from
**Southern
Water**

Your ref
Y/7/22/PL

Proposal: Erection of 4 No dwelling with access from Hoe Lane and associated landscaping, including native orchards and wildflower meadows. This application is a Departure from the Development Plan and is in CIL zone 3 and is CIL Liable as new dwellings.

Site: Y/7/22/PL: - Land adjacent to Bonhams & Flints, Hoe Lane, Flansham PO22 8NP.

PROPOSED SITE PLAN

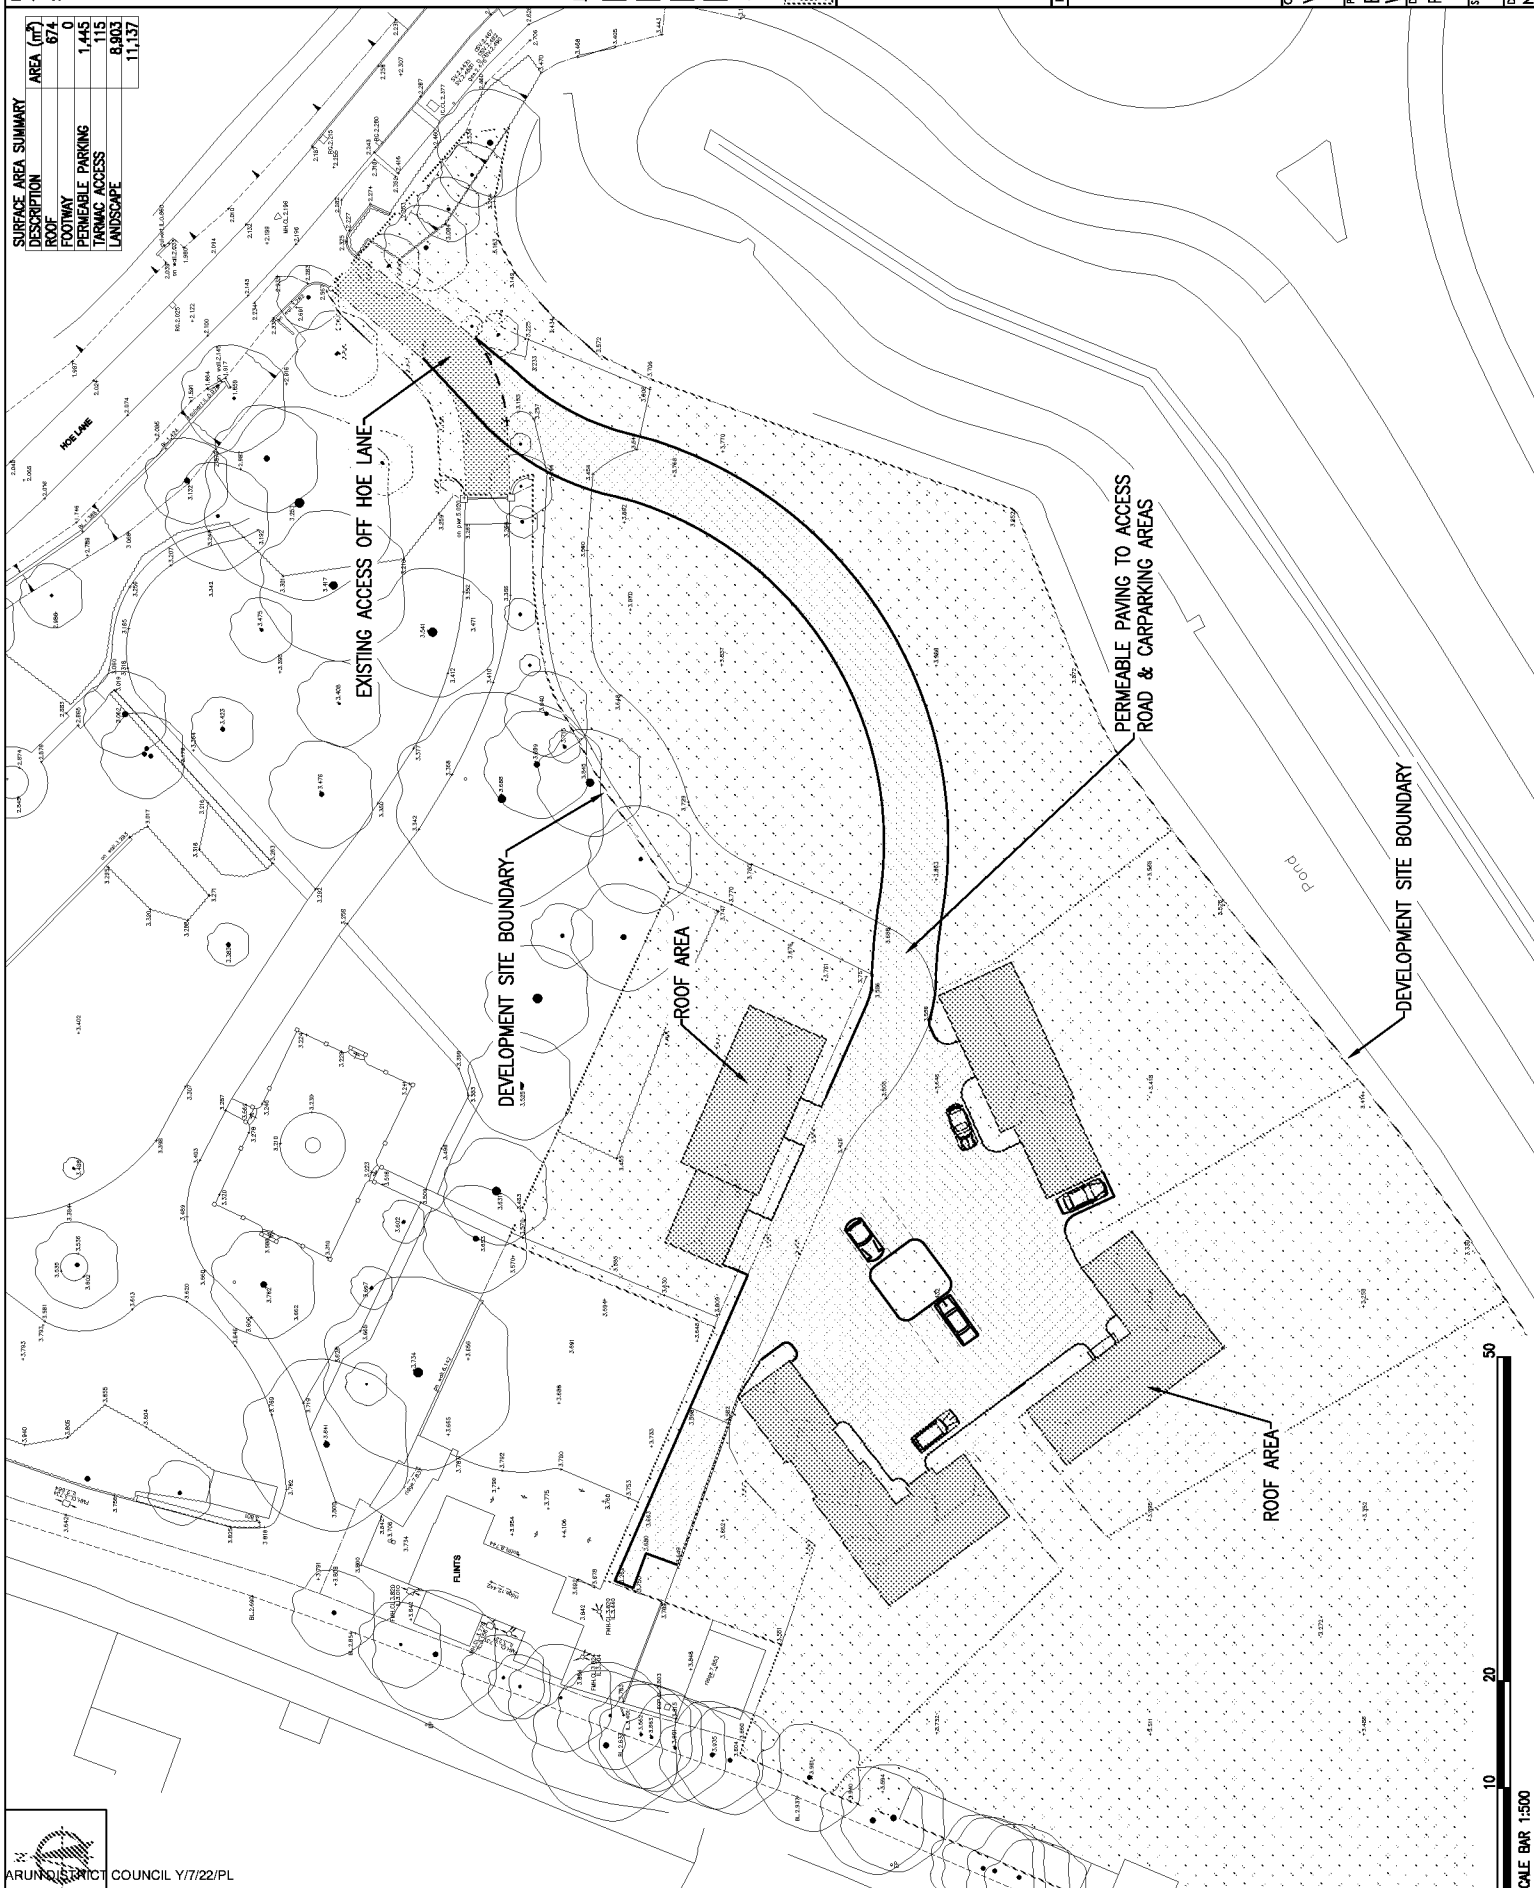
The attached plan shows that the proposed development will lie over an existing public foul rising main, which will not be acceptable to Southern Water. The exact position of the public apparatus must be determined on site by the applicant before the layout of the proposed development is finalised.

It might be possible to divert the rising main, so long as this would result in no unacceptable loss of hydraulic capacity, and the work was carried out at the developer's expense to the satisfaction of Southern Water under the relevant statutory provisions.

- The 600 public foul rising main requires a clearance of 3 metres on either side of the public rising main to protect it from construction works and to allow for future access for maintenance.
- No development or tree planting should be carried out within 3 metres of the external edge of the public rising main without consent from Southern Water.
- No soakaways, swales, ponds, watercourses or any other surface water retaining or conveying features should be located within 5 metres of public rising mains.
- All existing infrastructure should be protected during the course of construction works.

Alternatively, the applicant may wish to amend the site layout, or combine a diversion with amendment of the site layout. If the applicant would prefer to advance these options, items above also apply.
